From: Sue Howell
Sent: 26 September 2017 11:48
To: Simon Davis
Subject: RE: PLANNING APPLICATION REF. Y/40/17/OUT - BONHAMS, HOE LANE, FLANSHAM

Subject: PLANNING APPLICATION REF. Y/40/17/OUT - BONHAMS, HOE LANE, FLANSHAM

Having seen the consultee comments from your Greenspace colleague Sue Howell, can I respond to her comments in terms of the amount and layout of the open space within the proposed development. As we have discussed previously it needs to be born in mind that the application is for outline permission with layout a reserved matter; the submitted layout is therefore indicative rather than final.

BS Calculated root protection areas

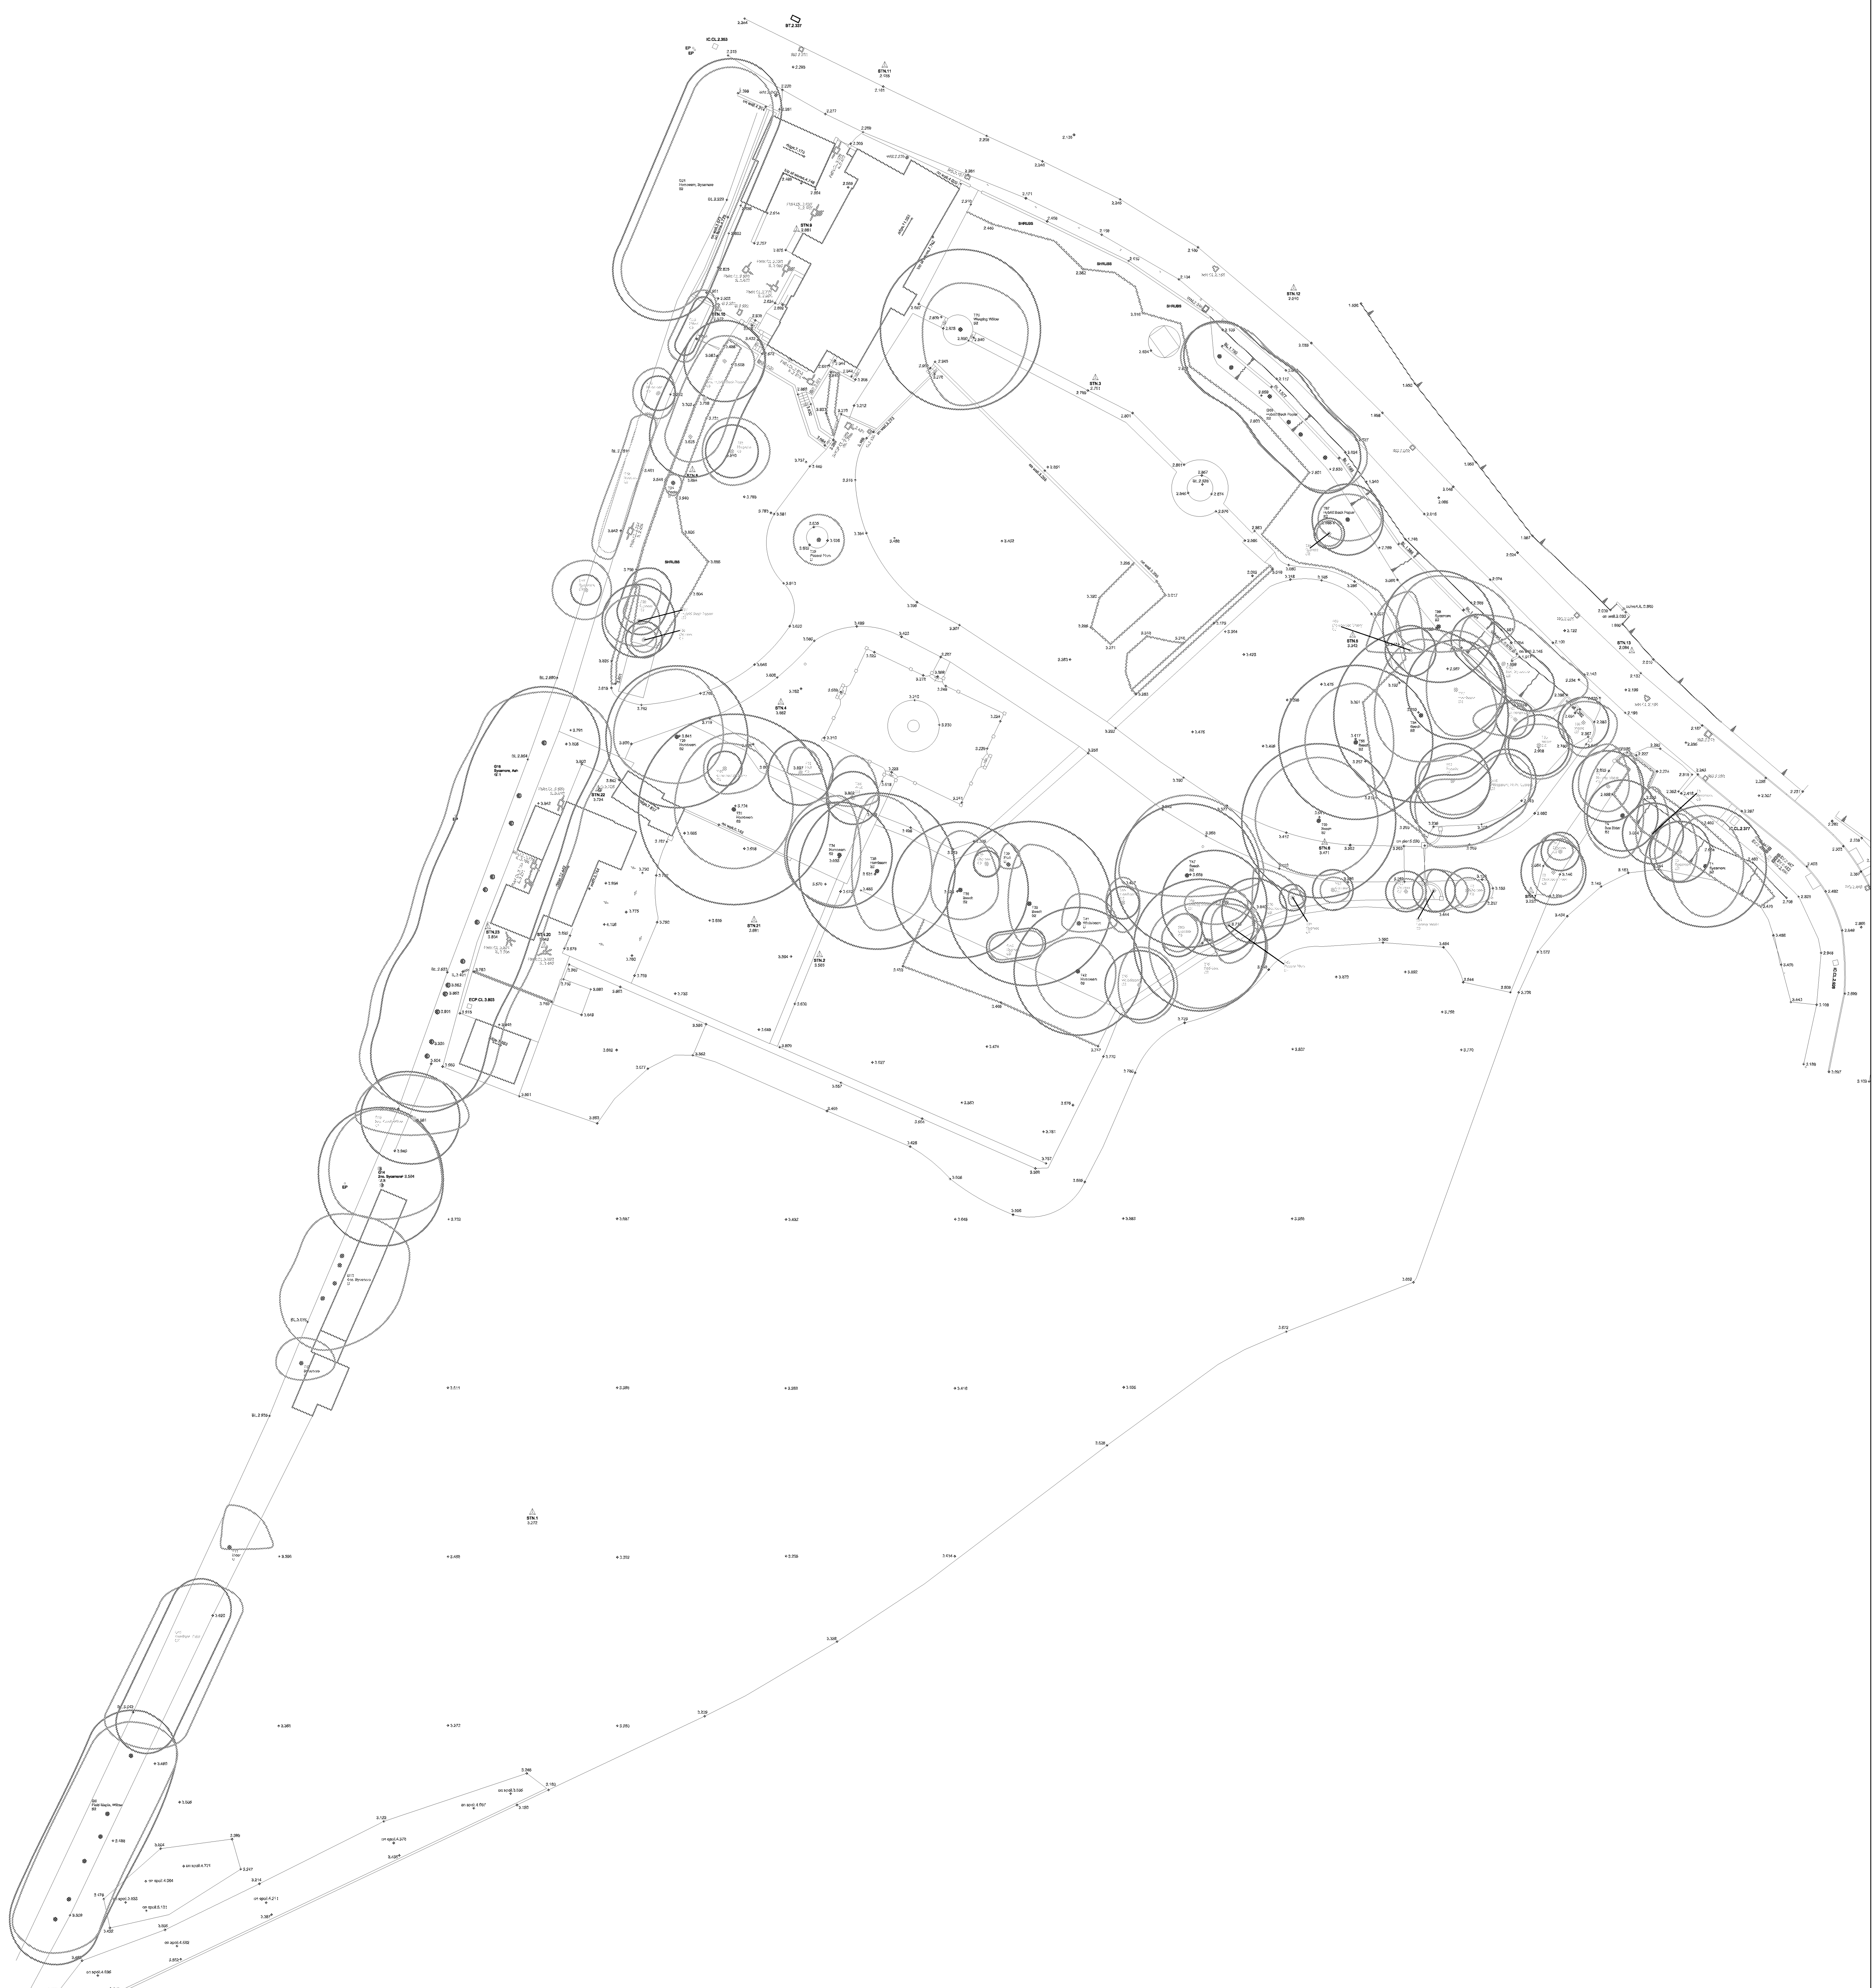
The Greenspace comments also refer to trees within the site. The attached drawing shows the root protection areas for the existing trees to be retained. A report on the inspection of trees and a tree constraints plan were submitted as part of the application documentation and the indicative layout is careful to avoid impinging on the RPAs of existing trees to be retained. There is only one instance where any building impinges on a RPA; that is a very small area for the garage to plot 04, which could be easily resolved by the use of a special foundation for that part of the building.
